Application by Ecotricity for an Order Granting Development Consent for the Heckington Fen Solar Park Project

The Examining Authority's written questions and requests for information (ExQ1)

Please find below answers to the Examining Authority's written questions from the Environment Agency (EA) [ref no. 20038495].

**WATER BODIES IN A RIVER BASIN MANAGEMENT PLAN**

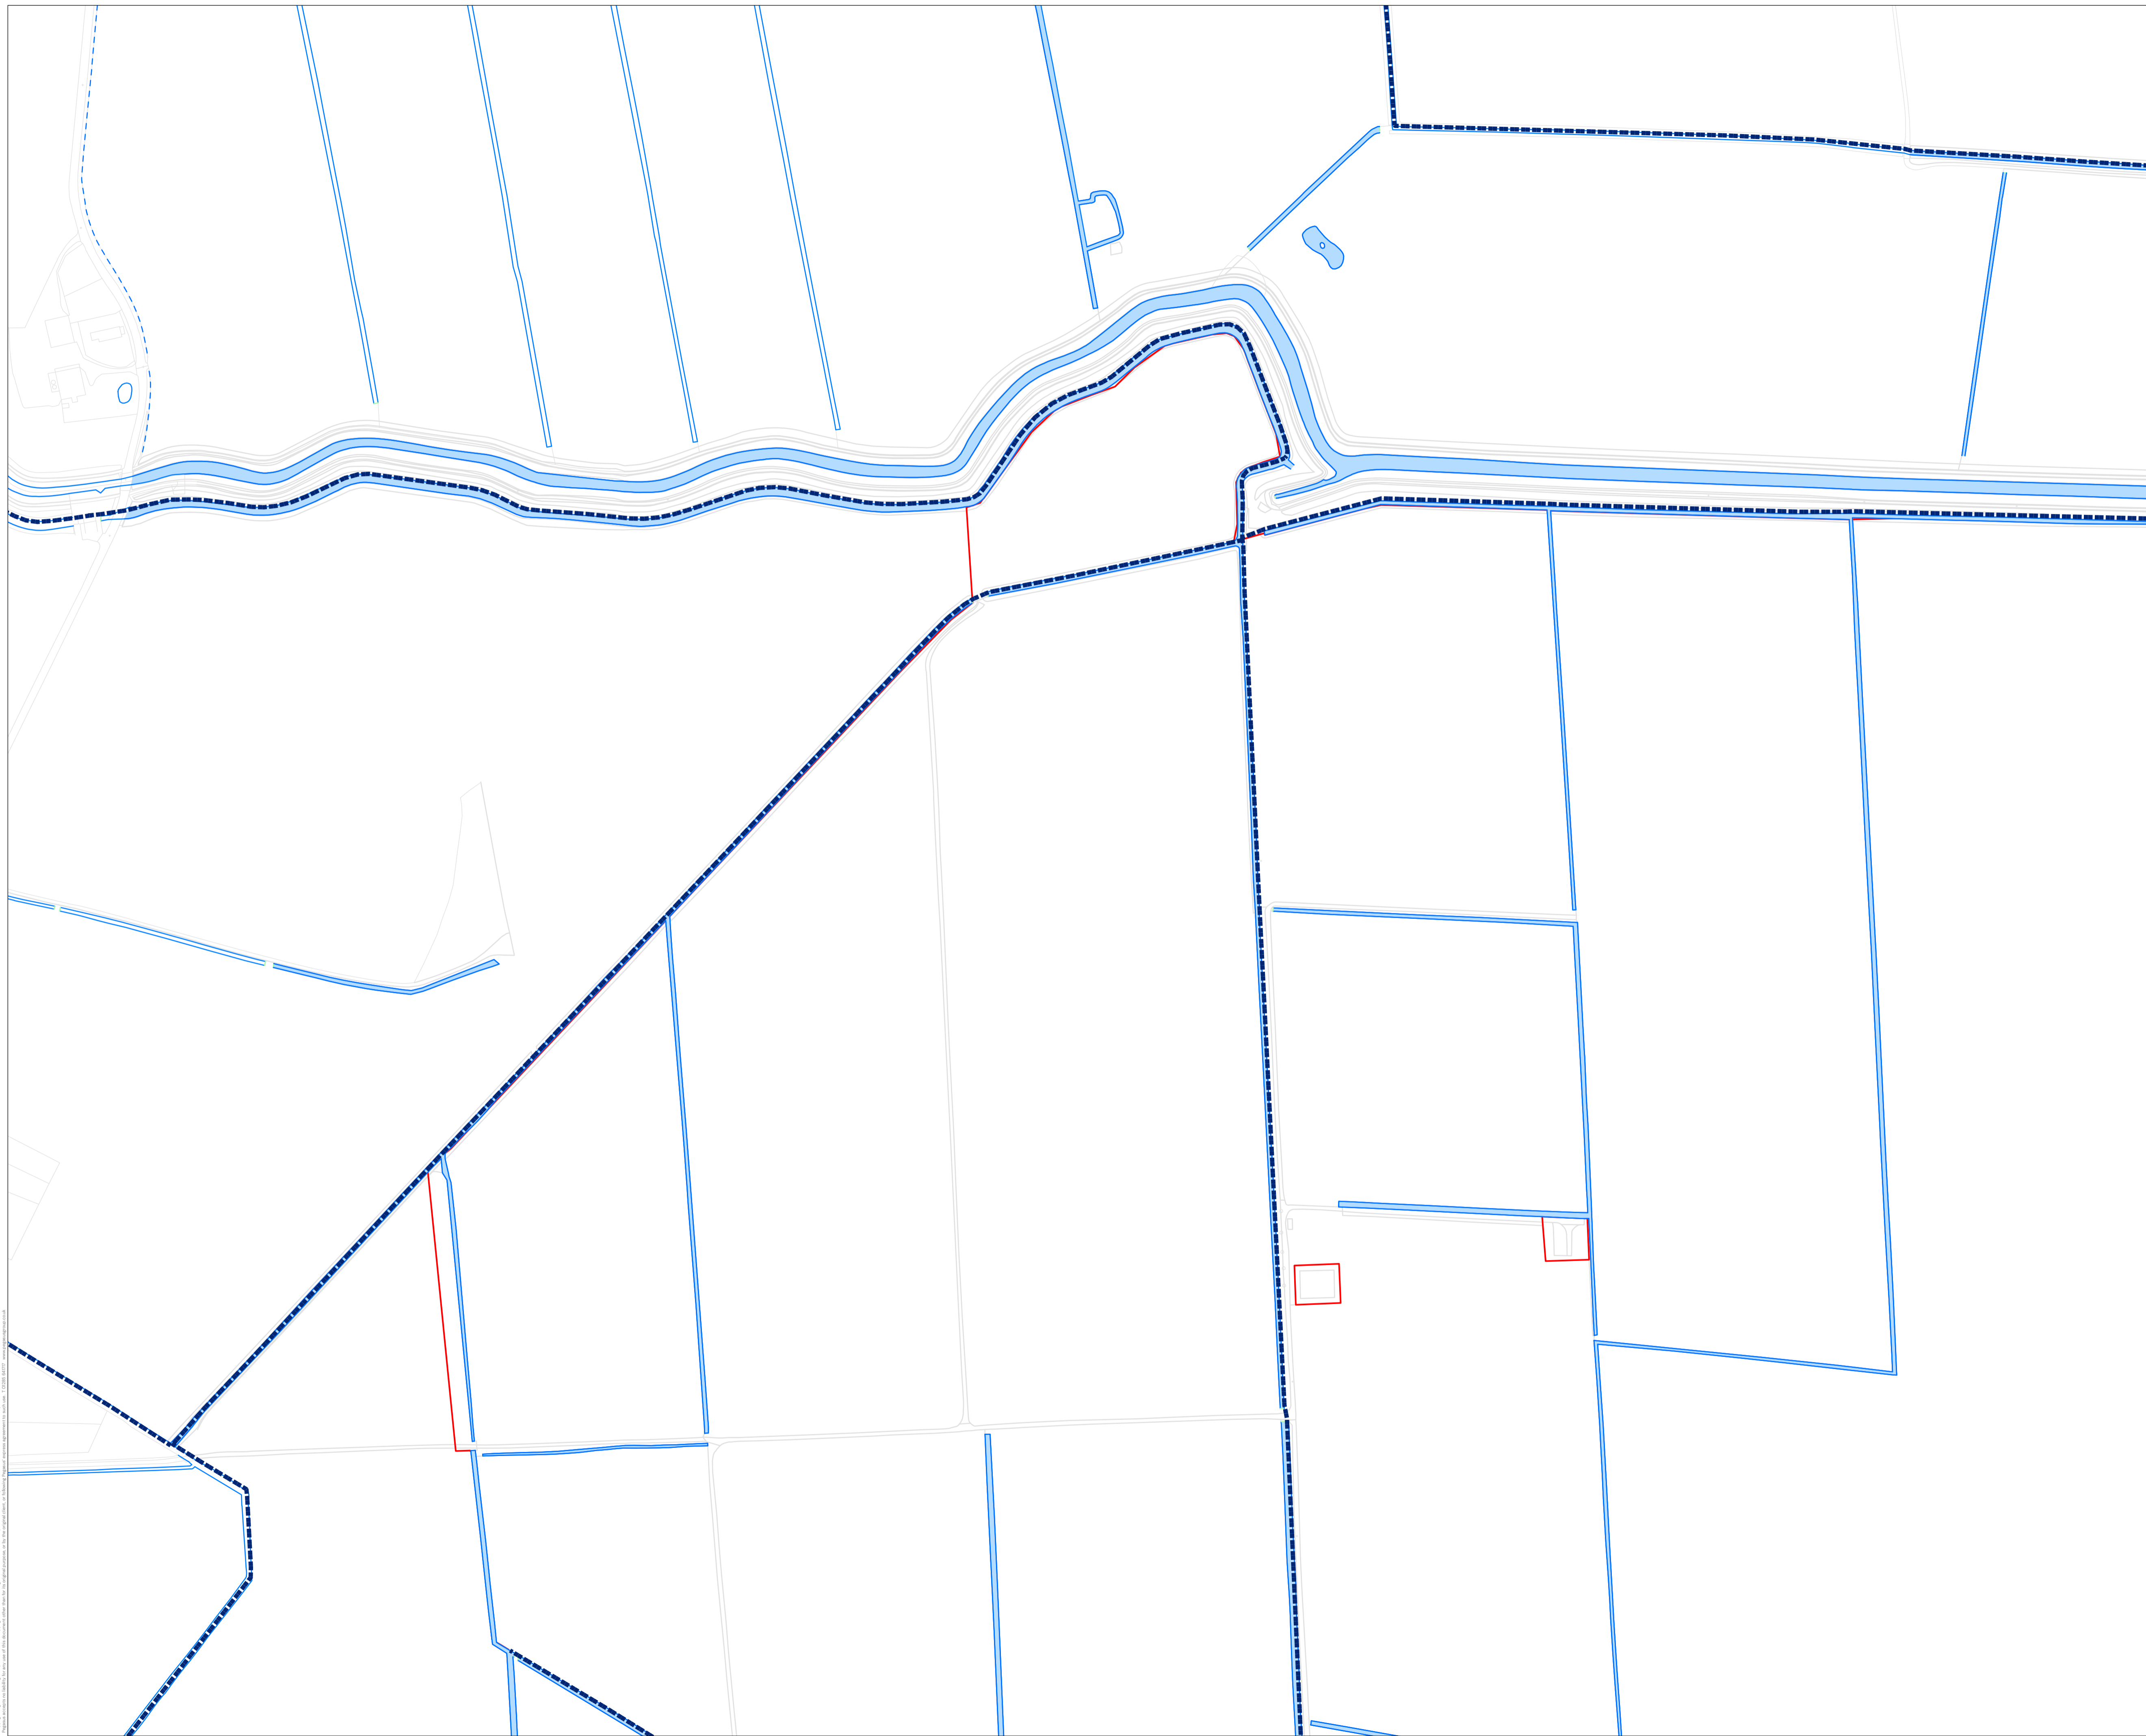
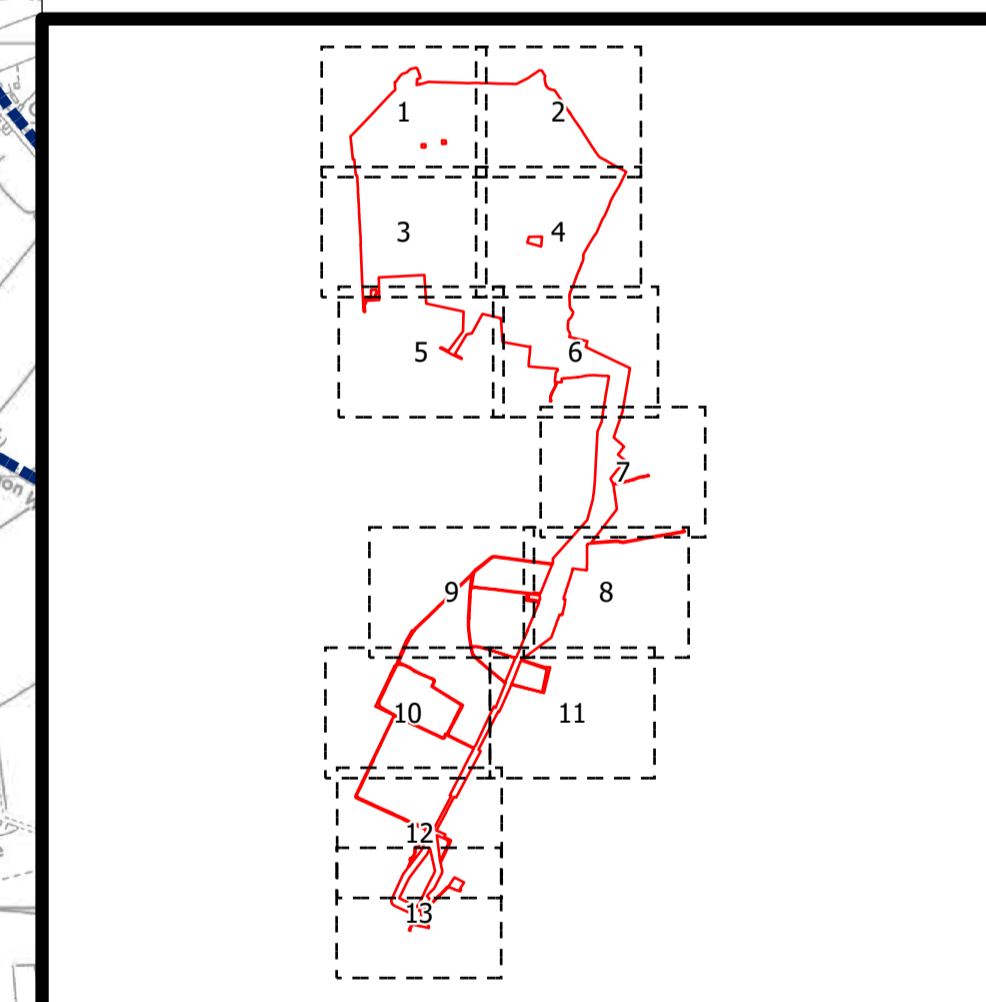
Ref No.	Question	EA response
WE.1.4	<p>Water Bodies in a River Basin Management Plan [PS-017] shows the range of watercourses which cross the Order Land and in the surrounding area, many of which will need to be crossed by the Proposed Development.</p> <p>i) Could the Applicant clarify how the directional drilling or similar technology under the IDB drains and other major wet drains would be controlled through the DCO process?</p> <p>ii) Could the IDB, the EA and Lead Local Flood Authority (LLFA) provide any further comments they wish to raise regarding the proposed methods of watercourse crossings and whether you consider the final details are able to be adequately secured by Requirement 6 of the dDCO [PS-024] alongside the protective provisions set out in Schedule 13 Parts 5 and 7.</p> <p>iii) For the smaller field ditches can the Applicant explain how these will be monitored for water retention and rainfall during</p>	<p>ii) Requirement 6 of the dDCO [AS-008] secures that the development accords with the Outline Design Principles [APP-232], and this specifies in Table 1.5 that Works No. 5, 5A and 5B will be undertaken using Horizontal Directional Drilling or similar technology for laying of the cables under the South Forty Foot Drain (the main river that falls under the jurisdiction of the Environment Agency). The protective provisions included in Schedule 13, Part 5 for the Environment Agency will ensure detailed plans and the methodology in relation to the main river crossing will need to be approved by us prior to the works taking place. Accordingly, we are satisfied that details are adequately secured in relation to those watercourses crossings under the Environment Agency's jurisdiction.</p> <p>iv) The Environment Agency is satisfied that subject to the identified mitigation within the outline Construction Environment Management Plan (oCEMP) being fully implemented and best practice methods being followed in respect of pollution prevention; as well as the relevant water abstraction licences and discharge permits being obtained prior to construction commencing for that activity, there should be no deterioration in waterbody status.</p>

Ref No.	Question	EA response
	iv) construction to ensure that silt run off is minimised. Could the EA, IDB or LLFA comment on the mitigation and monitoring measures.
